**Consultation Response from KC,
Trees**

**2023/92448 Former Cooper Bridge Water Treatment Works, Leeds Road, Huddersfield, WF14
0BT**

Outline application for erection of B8 industrial unit

Responding Ref: 36/92

SITE PLAN

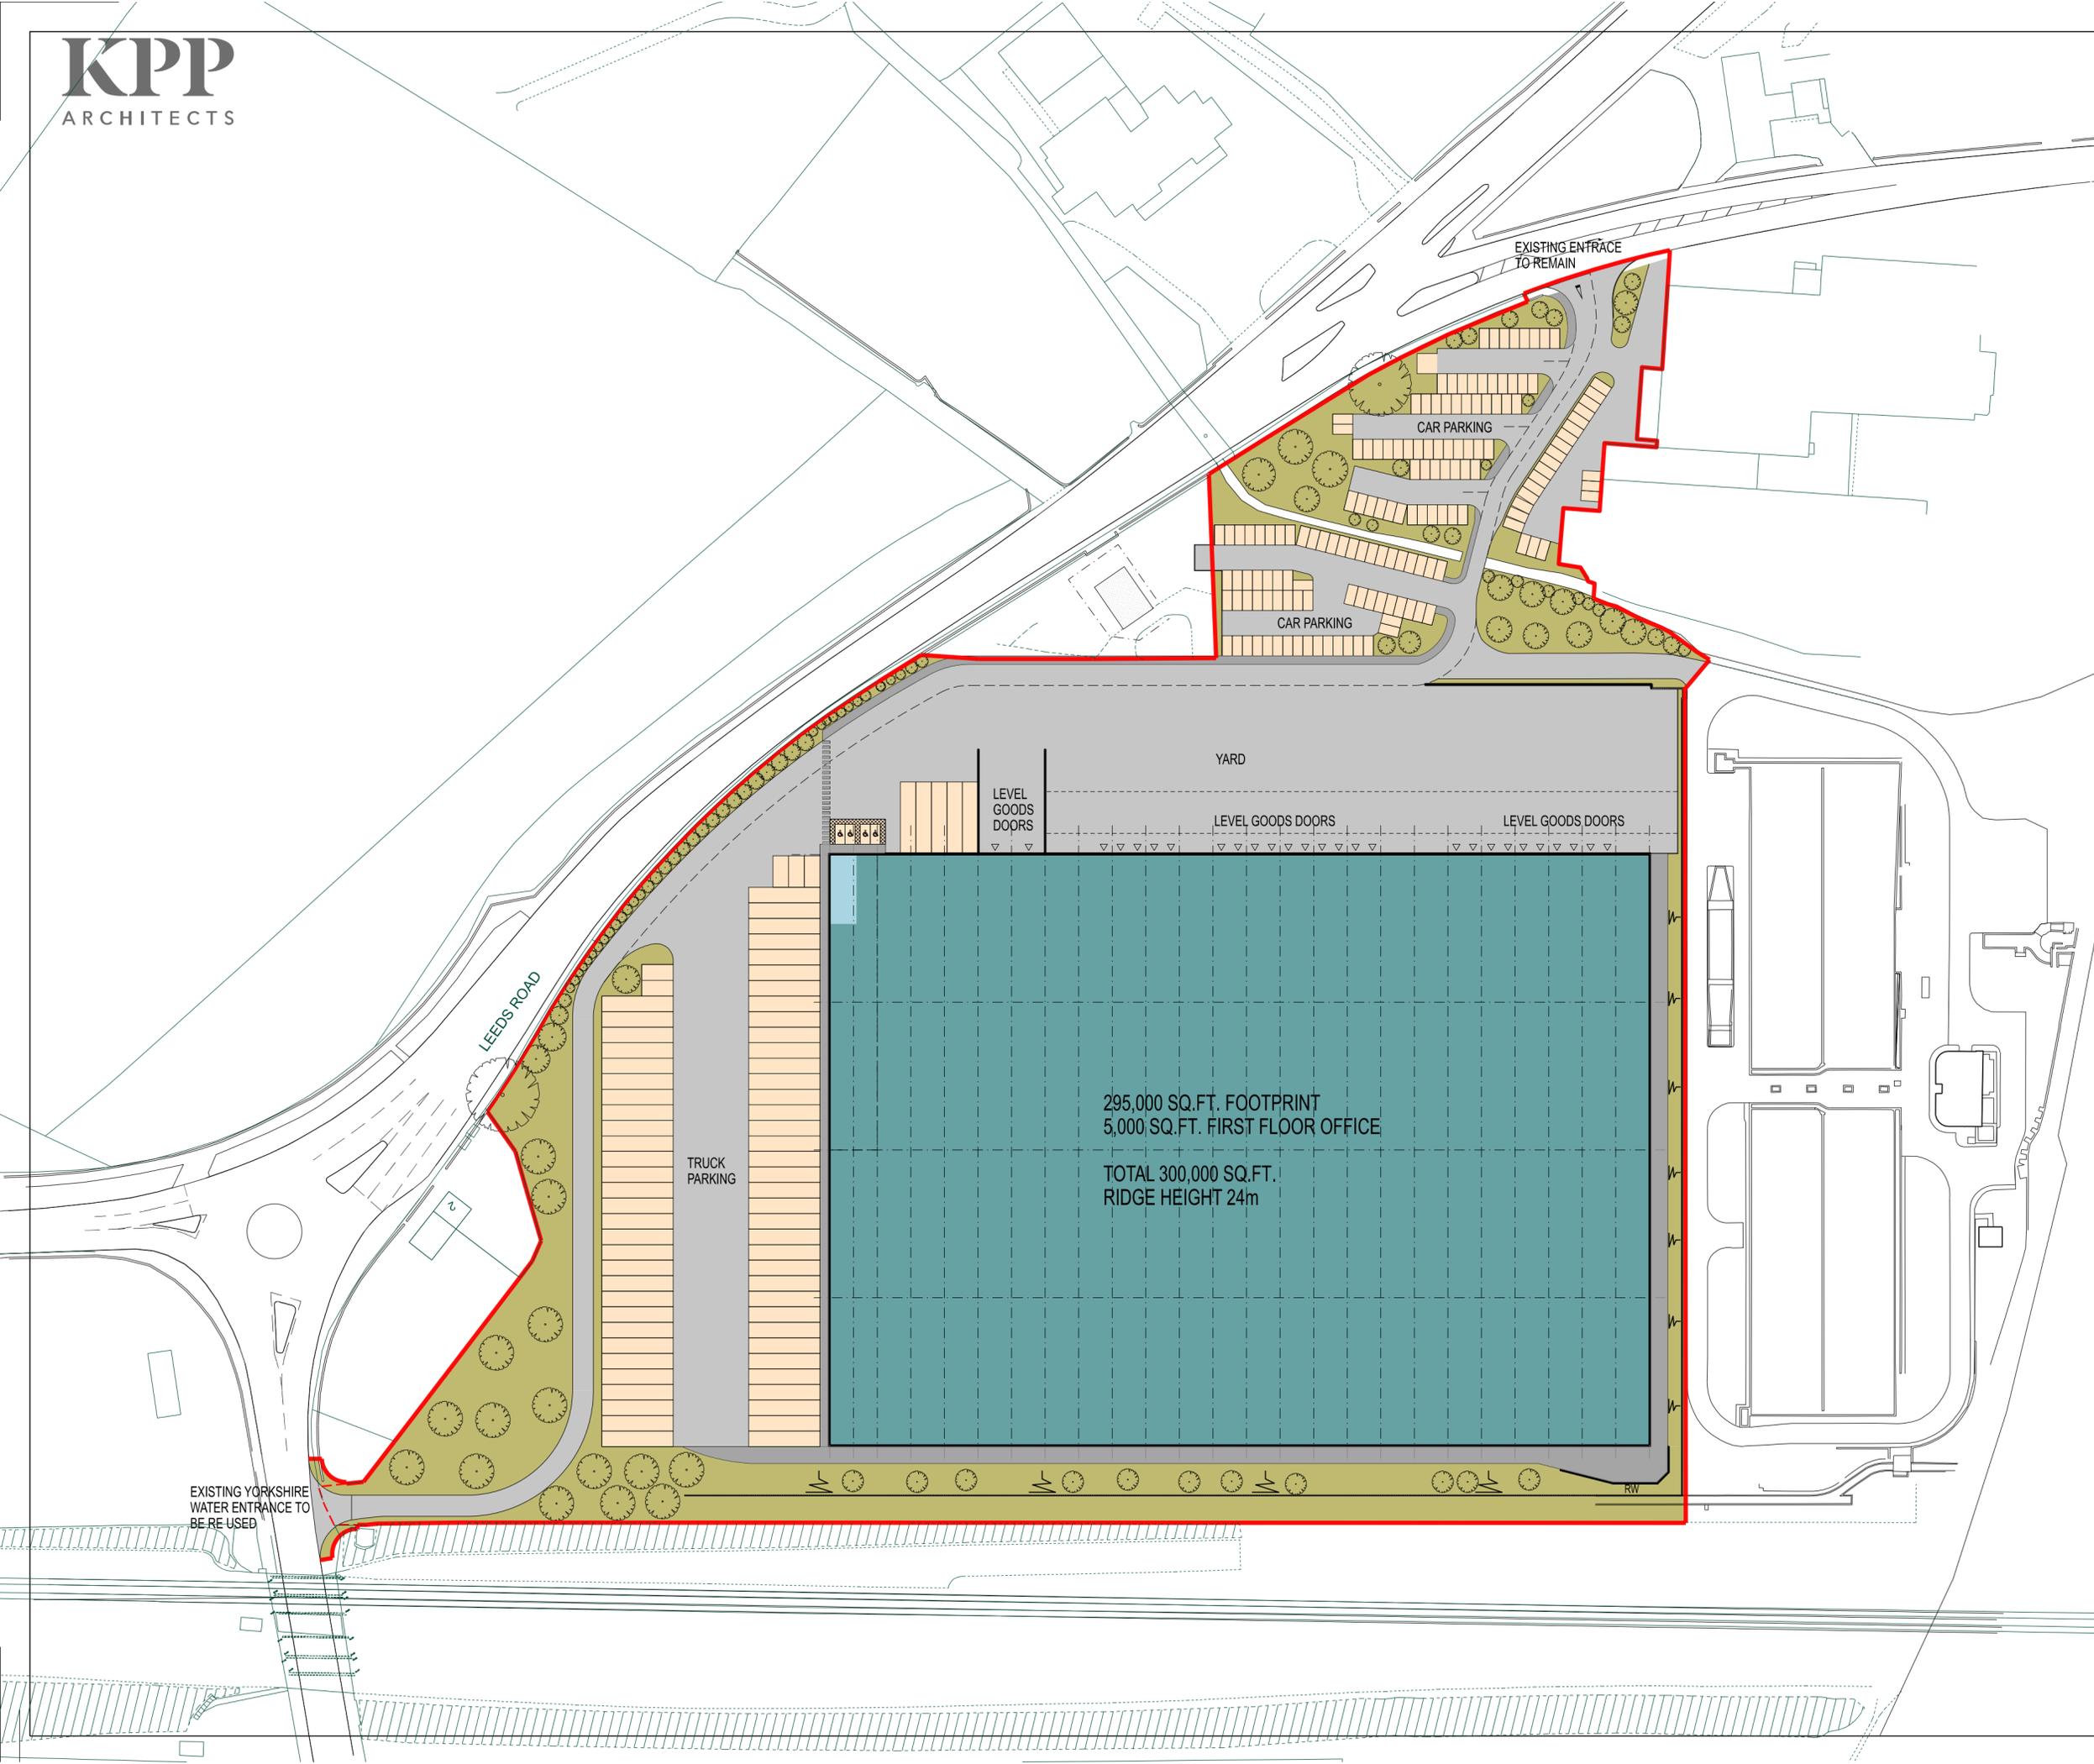
As a result the tree survey needs to be updated, so it records the position, RPA and canopy etc. of the other TPO'd trees that are within G2 and G4, like it does with T1. This is so they can be properly taken into consideration within the design/layout of the car parking the vicinity.

However, from the information provided. The site does contain high value trees protected or not (i.e. T1, G2, G4 and T5) have high arboriculture and landscape value. As a result they're very desirable to be retained within the development. So that they can continue to provide value to the site.

As a result the design should treat the RPA, canopy spread and space provision for future growth as sacrosanct and hold the default position in terms of placing new structures around them.

The default position should be that structures (i.e. manufactured object, such as a building, carriageway, path, wall, service run, and built or excavated earthwork) are located outside the RPAs of trees to be retained.
